# CITY OF PORTLAND BUILDING PERMIT

**PERMIT ID:** 2013-00509    **ISSUE DATE:** 04/09/2013    **CBL:** 062 C031001

has permission to **Install 6 solar electric panels; electric permit separate.**

**Dept:** Historic      **Status:** Approved w/Conditions      **Reviewer:** Deb Andrews      **Approval Date:** 04/01/2013  
**Note:** **Ok to Issue:**

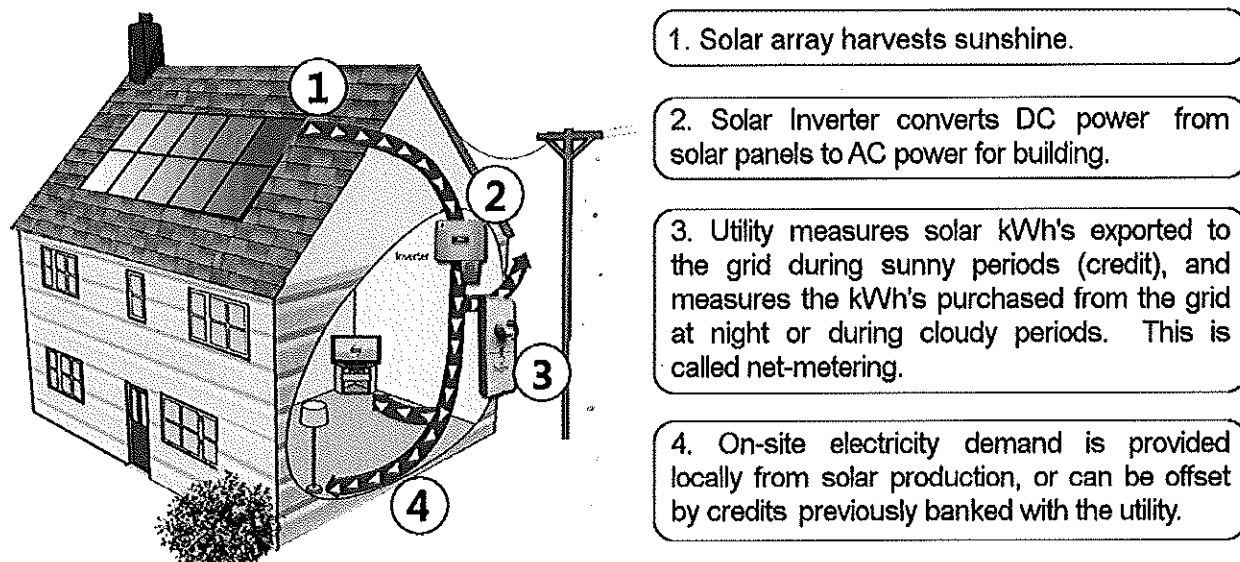
1) Panels originally proposed for front roof plane not approved--only those proposed for dormer roof.

•The edges of the panels will be finished in a dark, recessive color to match the roofing material. (If painted in the field, the metal should be primed to ensure that the paint adheres.)

•Any necessary conduit for the panels shall not be visible from Spruce Street.
